22 October 2010

**Major Project – MP10_0060 – Exhibition of Environmental Assessment –
Redevelopment of Sydney Fish Markets**

Allan Young
Manager Property Planning
Property, Planning & Infrastructure Division

MARITIME ENGINEERING SECTIONS 1-3

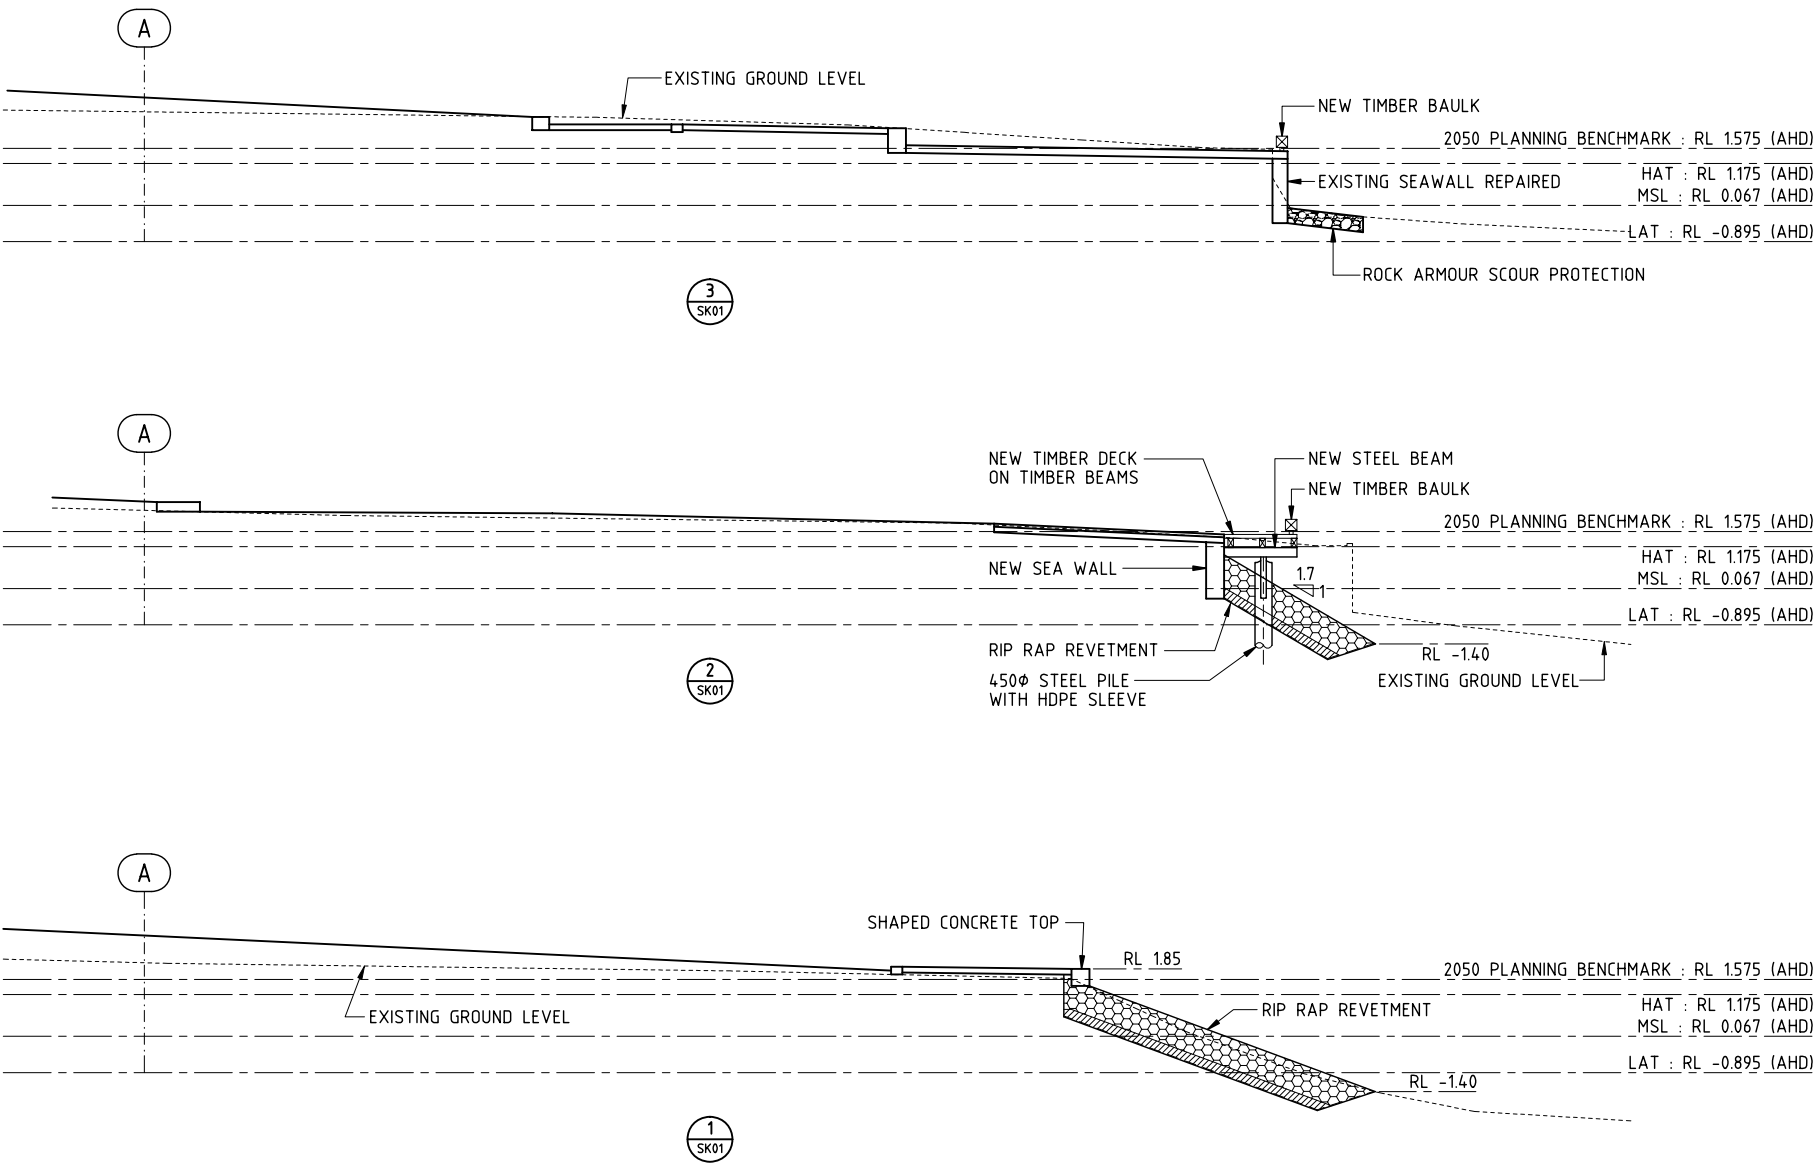
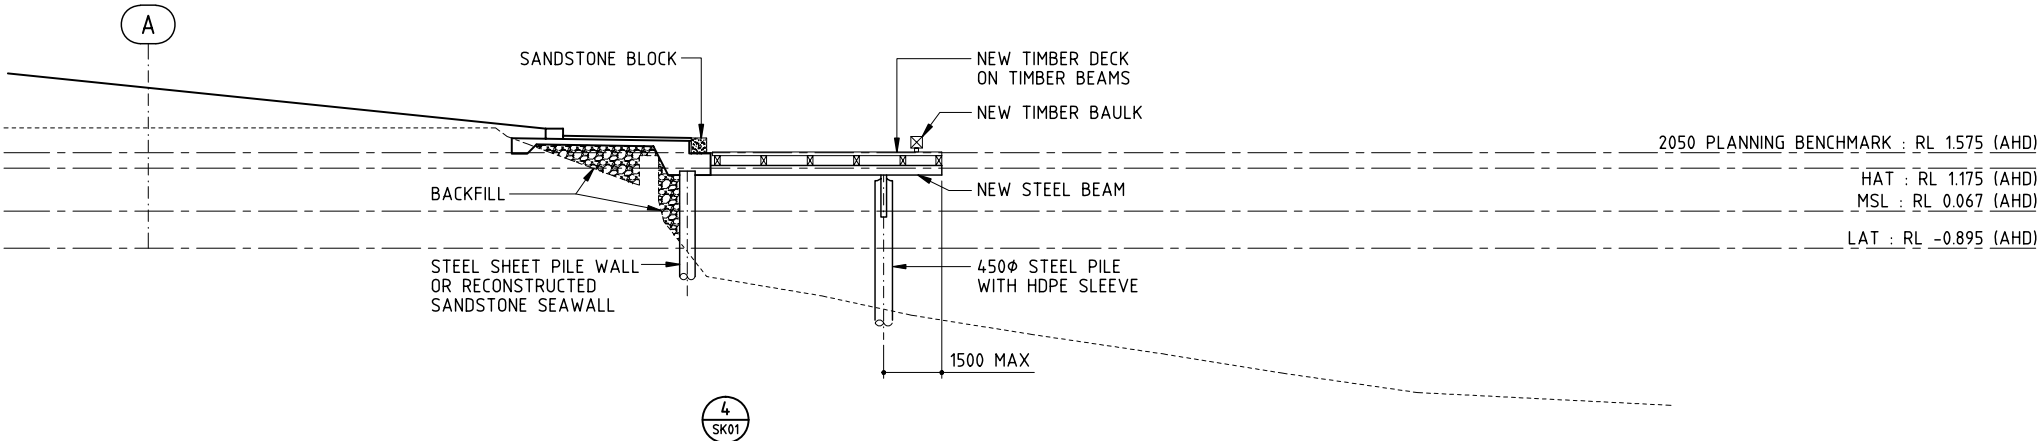
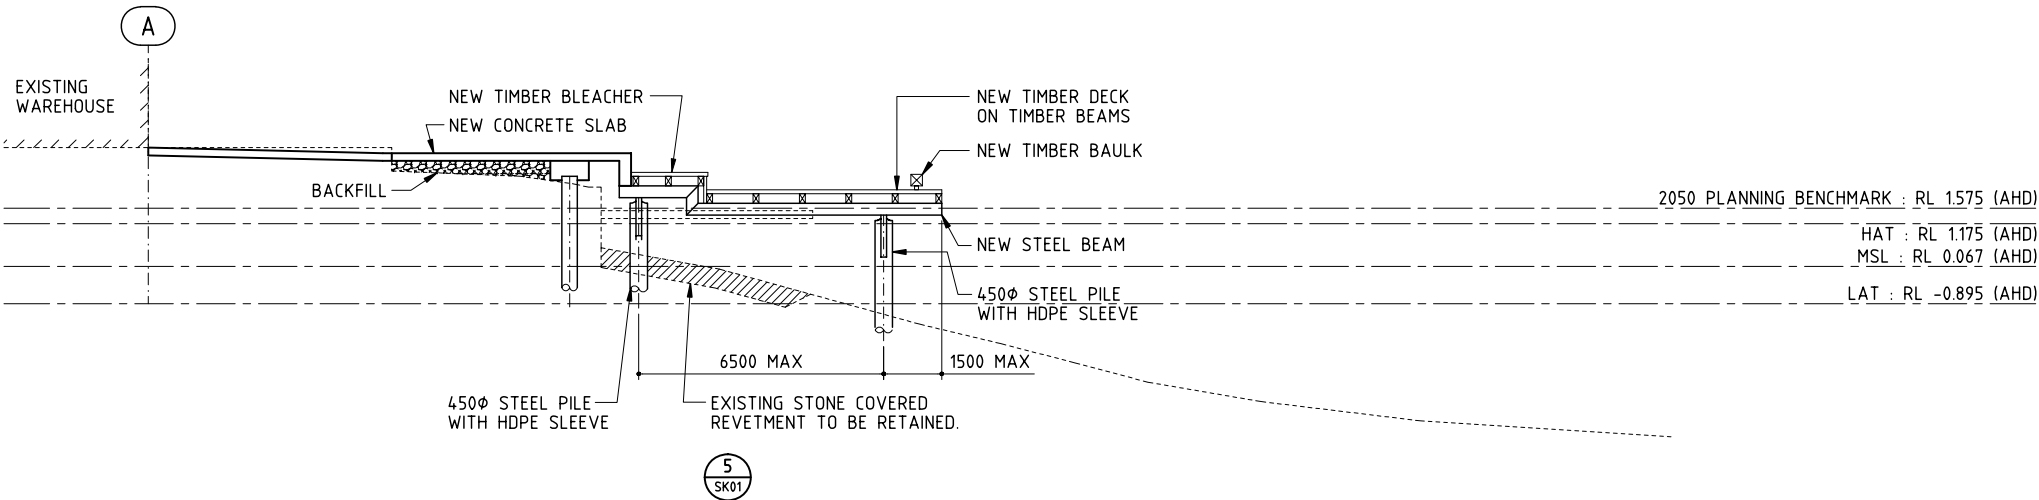
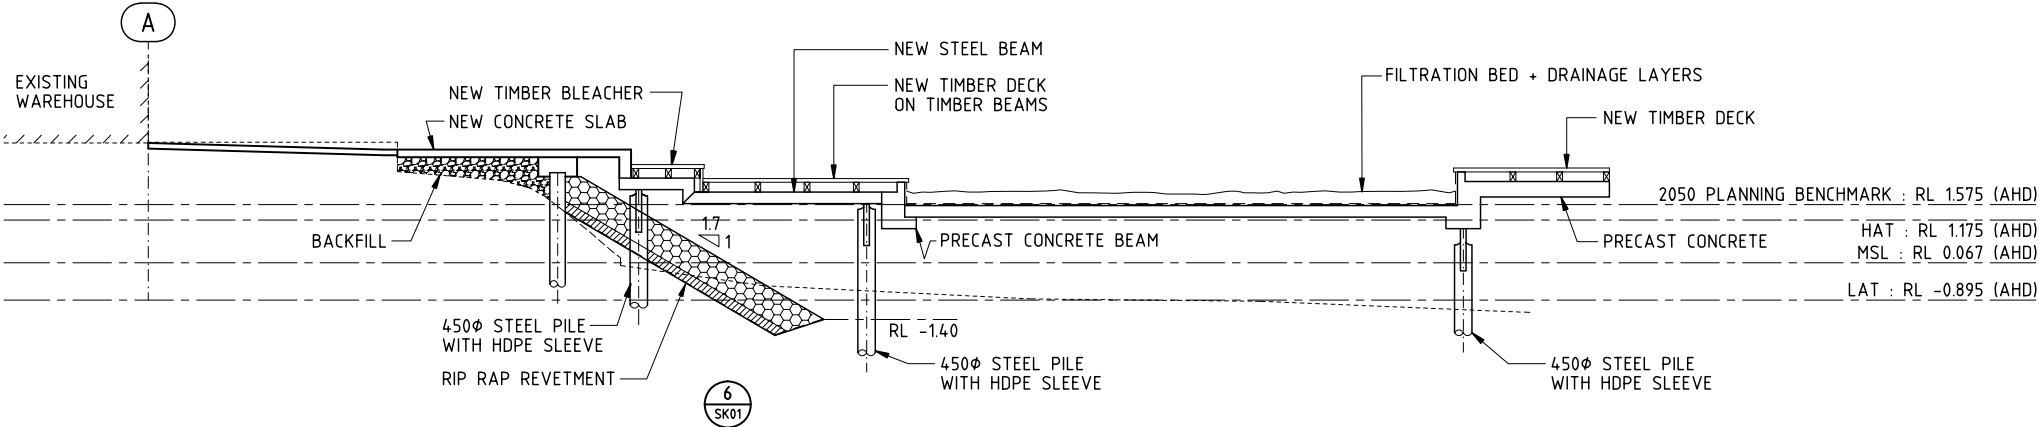
- b) Detailed design of the proposed reed bed and the boardwalk interface, including levels, demonstrating that adequate and ongoing access to the adjoining westerly sea wall is maintained. Any design should be coordinated with NSW Maritime;

- c) Plans detailing the levels of the interface between the Sydney Fish Market (SFM) site and the adjoining BBM. The finished level of the boardwalk should be suitably managed to create a public space that will comply with the *Disability Discrimination Act* and that does not require handrails; and
